# KITTITAS COUNTY

## DEPARTMENT OF PUBLIC WORKS

TO: All Staff  
FROM: Public Works Planning Review Team  
DATE: January 26, 2021  
SUBJECT: VA-20-00013 Pratt

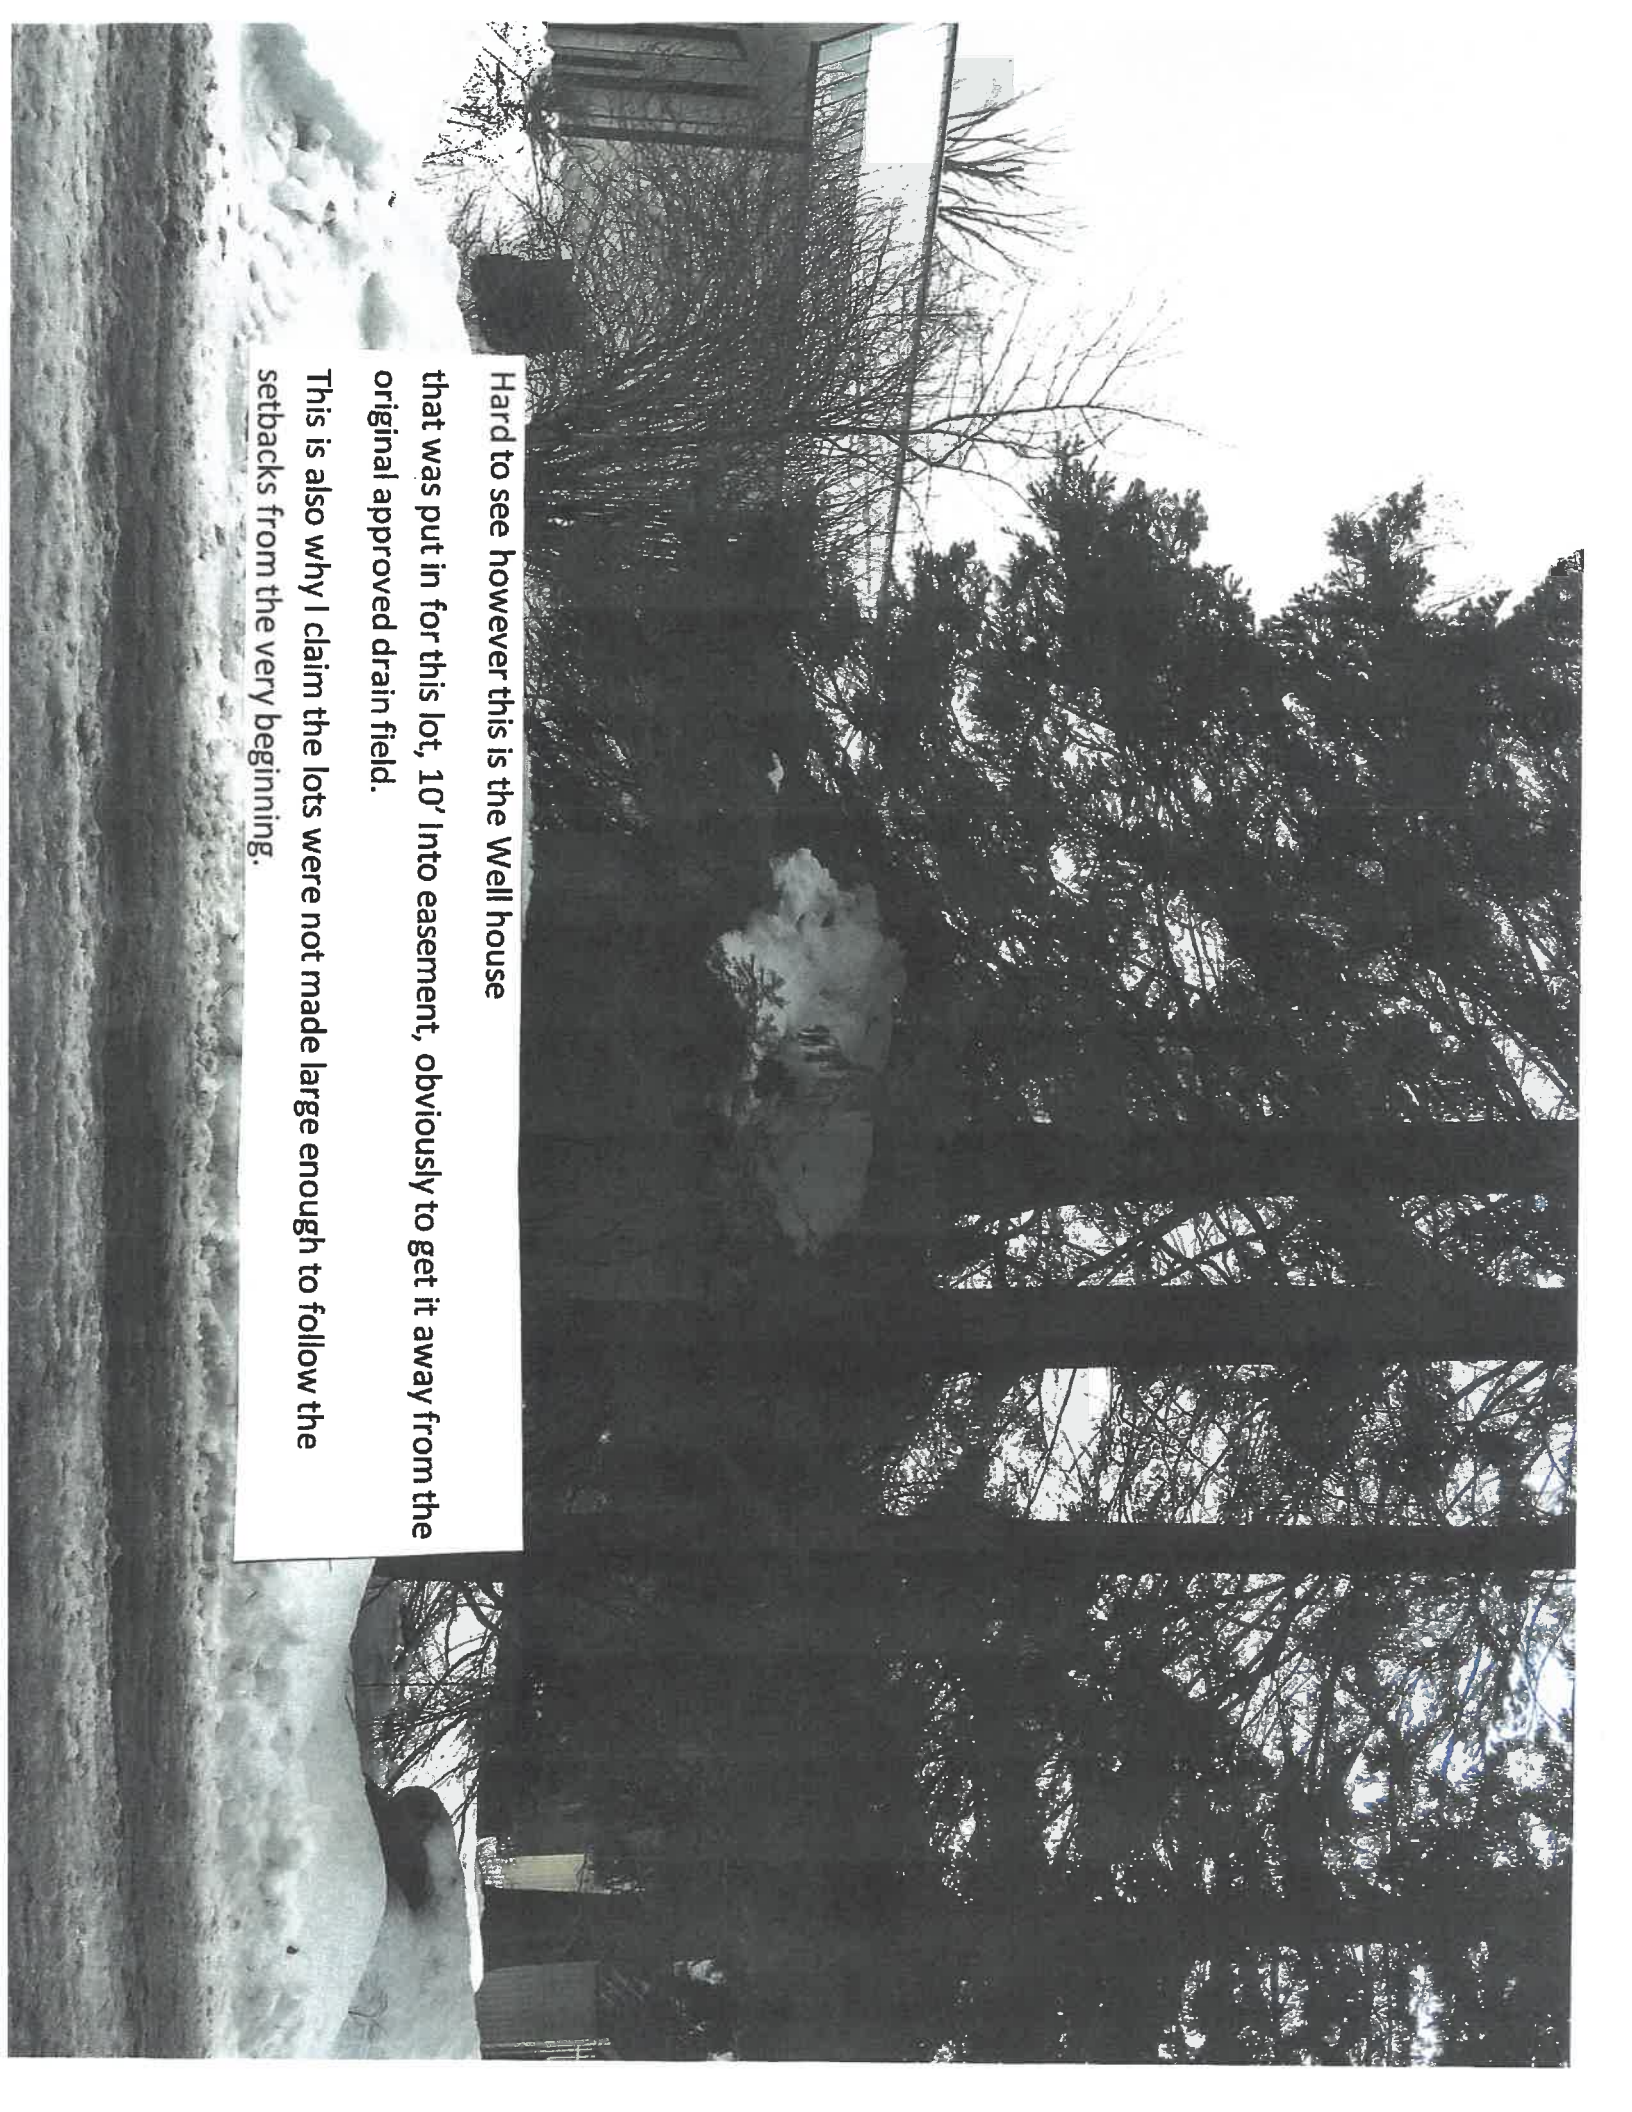
- A. An access permit would be required when a building permit is applied for.
- B. Any grading over 100 cubic yards of material will require a grading permit from Public Works.
- C. The narrative provided by the landowner describes a septic system and a creek on the property which requires the house to be pushed right up against the property line. However, these features aren't shown on the site map and it is unclear whether the original septic system was moved due to set-back requirements. Please provide a site map which details all set-back requirements, structures, and site features relating to this project. As it is currently shown, public works does not support a 1' set back due to potential conflict with future development of the private road intersection.
